Our Reference: SYD16/01626
Department Ref: SSD 8114

LINDFIELD LEARNING VILLAGE - 100 ETON ROAD, LINDFIELD

Roads and Maritime has reviewed the submitted application and does not support the development in its current form and provides the following comments for consideration:

Figure 2: Proposed design swept path using 12.5m buses

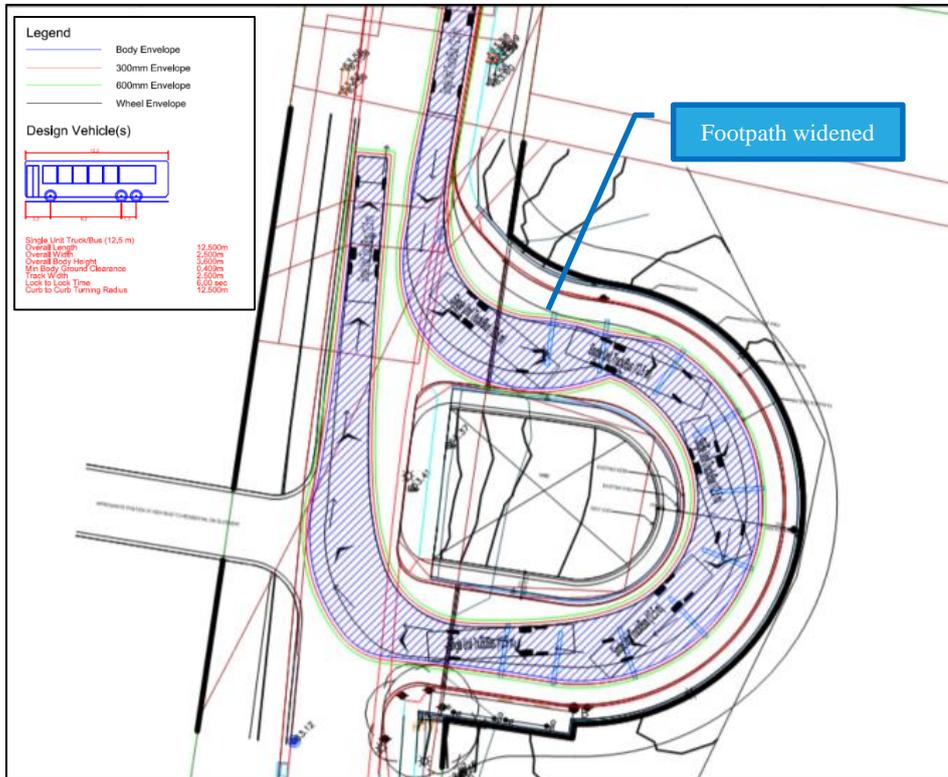
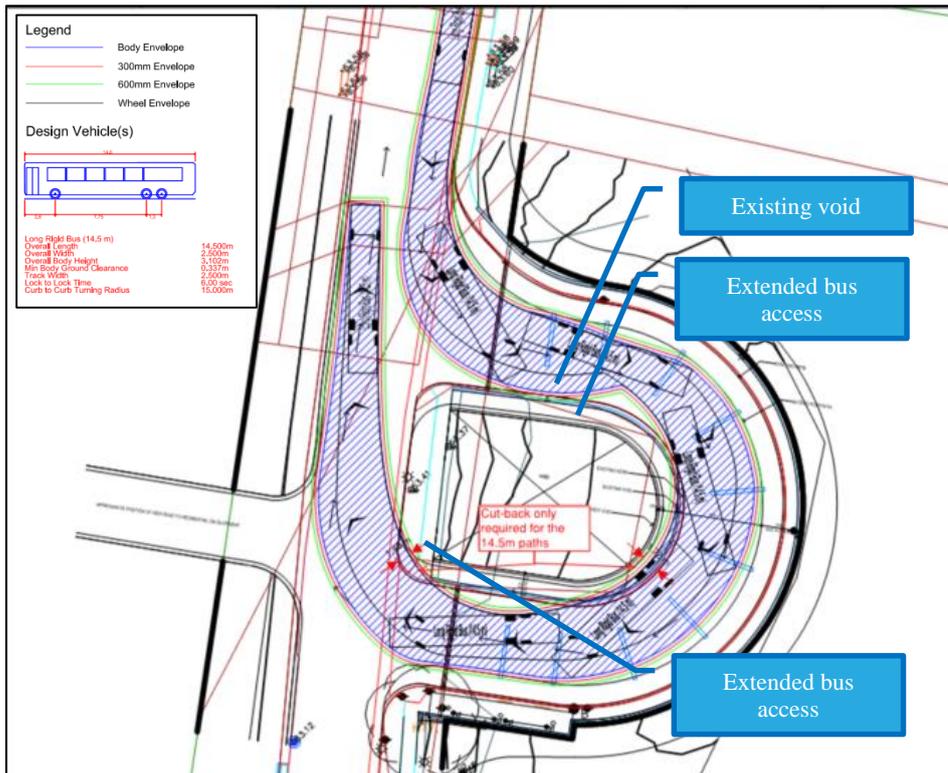
- Bus swept paths (figure 38) indicate buses will be unable to pull parallel to bus rank entry. Heavy student queues will result in students stepping on the pavement to enter the bus causing a safety issue when buses fill up and need to move on.

- Buses using the bus bay do not appear to have enough clearance to safely navigate the bus bay without rubbing up against concrete walls or pedestrian fences. The 600mm body clearance has not been achieved.

Figure 27: Lengthened right turn bay with indented bus bay

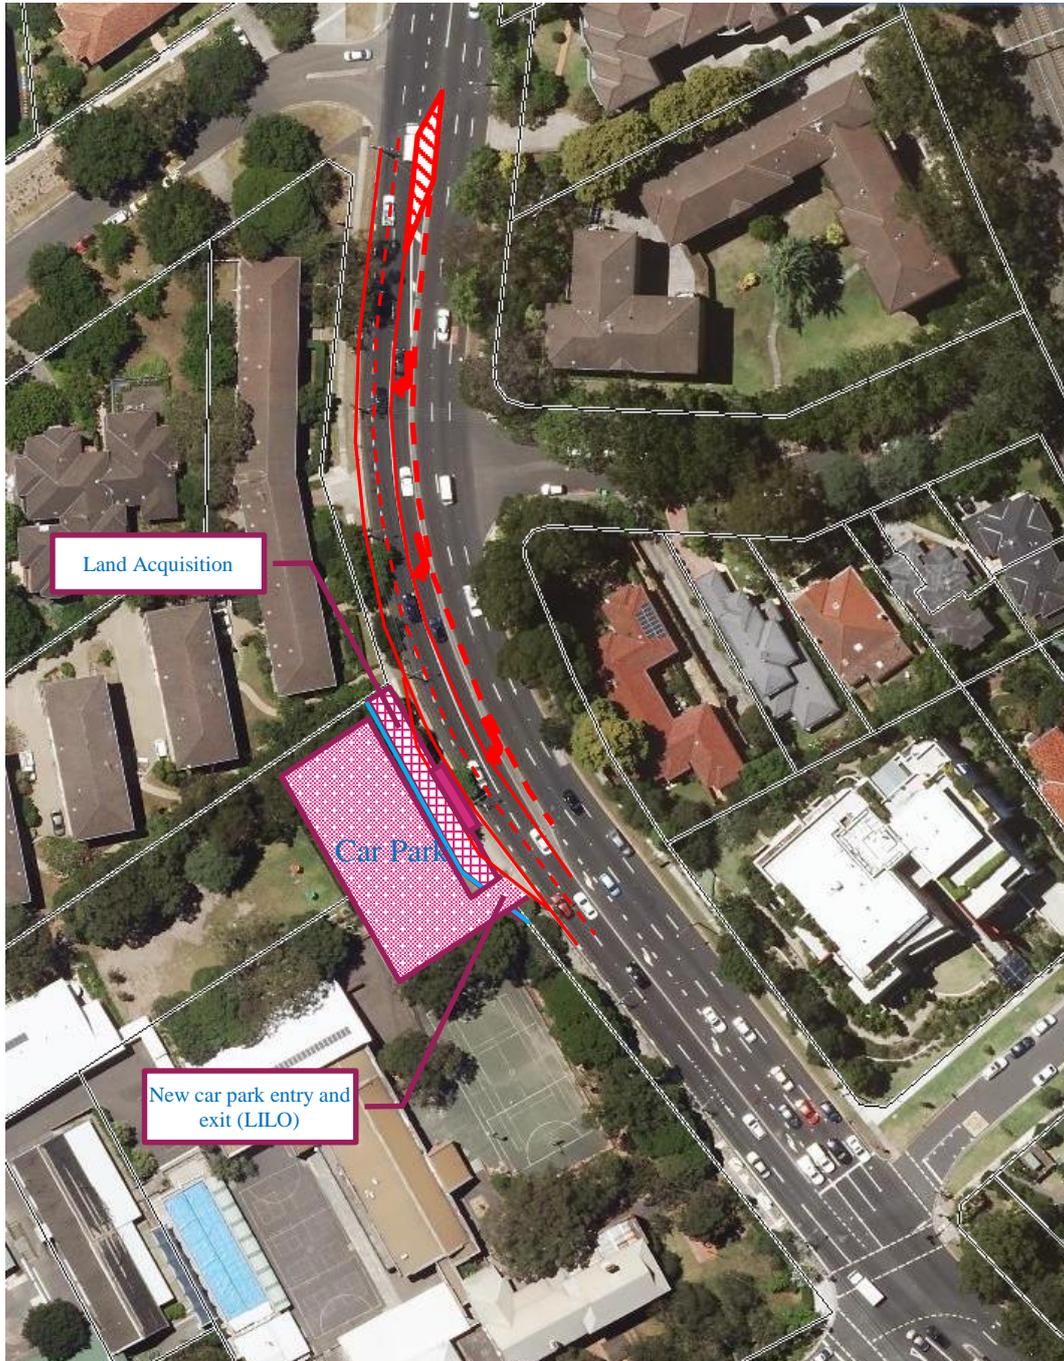
8. It is **not** acceptable to remove the bus stop on Pacific Highway to facilitate right turn extension. Roads and Maritime requires further information regarding the impacts of extending the Pacific Highway right turn lane into Grosvenor Road without removing the existing bus stop:

- A civil investigation incorporating the property impacts and a cost estimate of works (including utility relocation).
 - The modelling assessment indicates that the proposed right turn bay extension to 170m is shorter than the future queue length of 200m. Roads and Maritime raises concerns that the queue will regularly block through traffic on the Pacific Highway and cause significant congestion.

Figure 28: Double right turn bay option

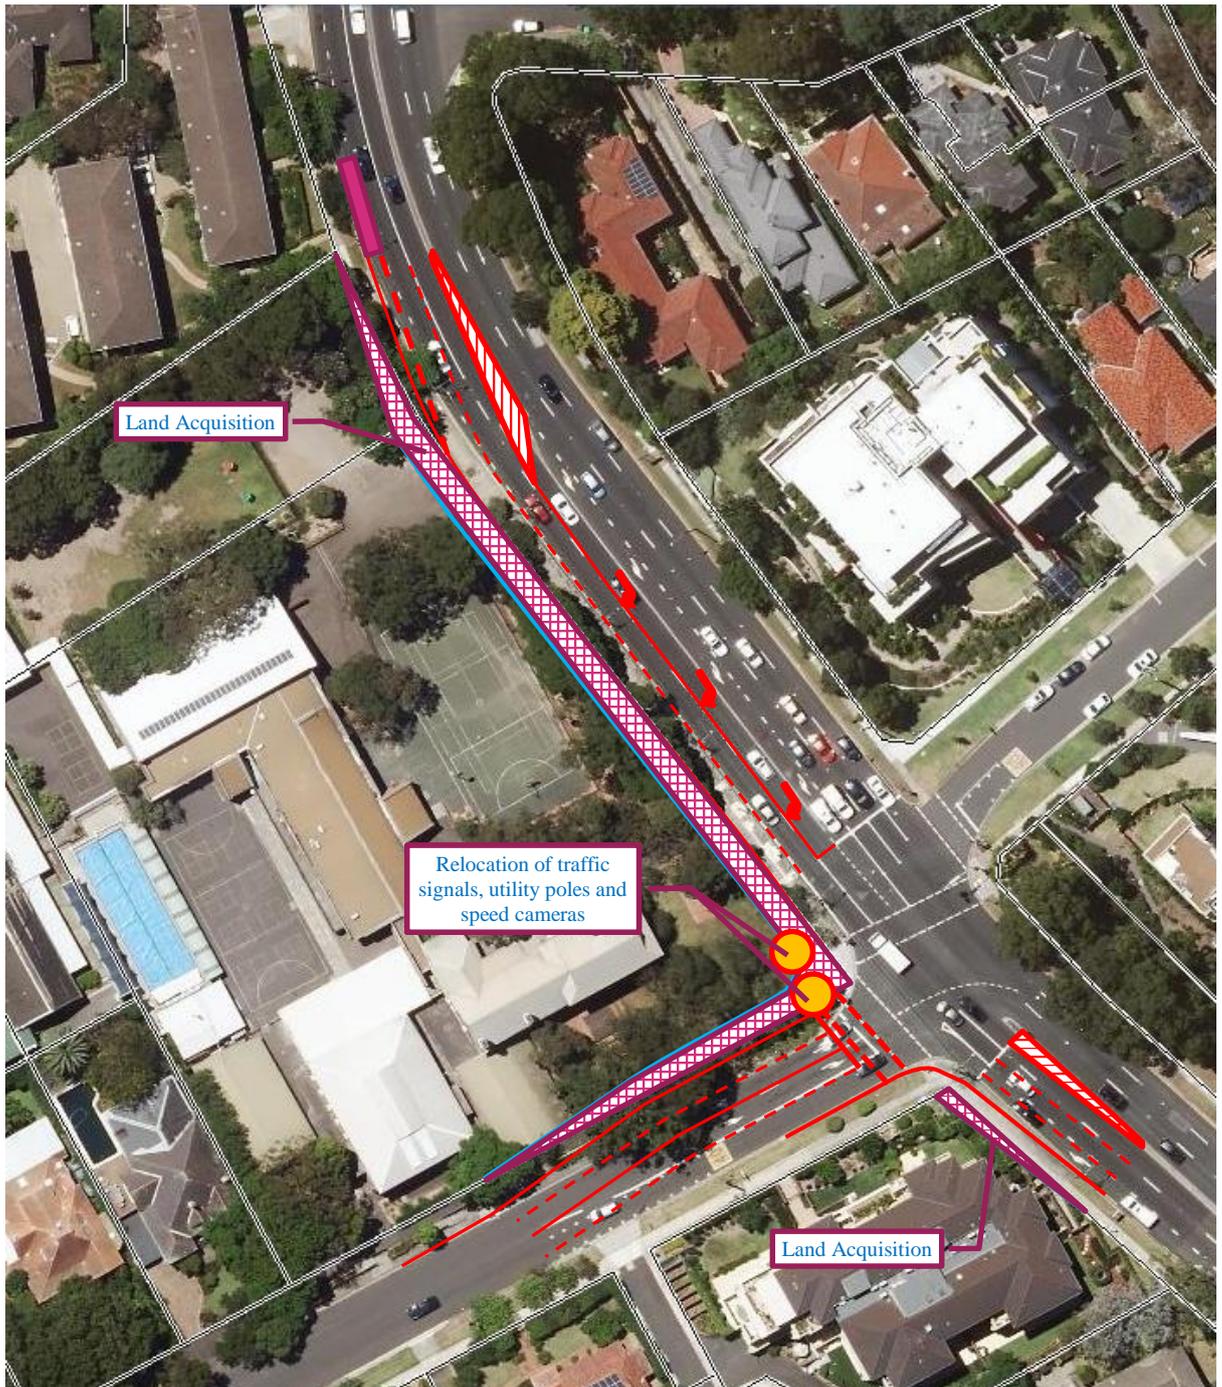
9. Roads and Maritime requests the applicant to investigate the following congestion alleviating upgrades.
 - Duplicate the Pacific Highway right turn bay into Grosvenor Road (including the entrance of Grosvenor Road) to accommodate the traffic generated by the proposed school.
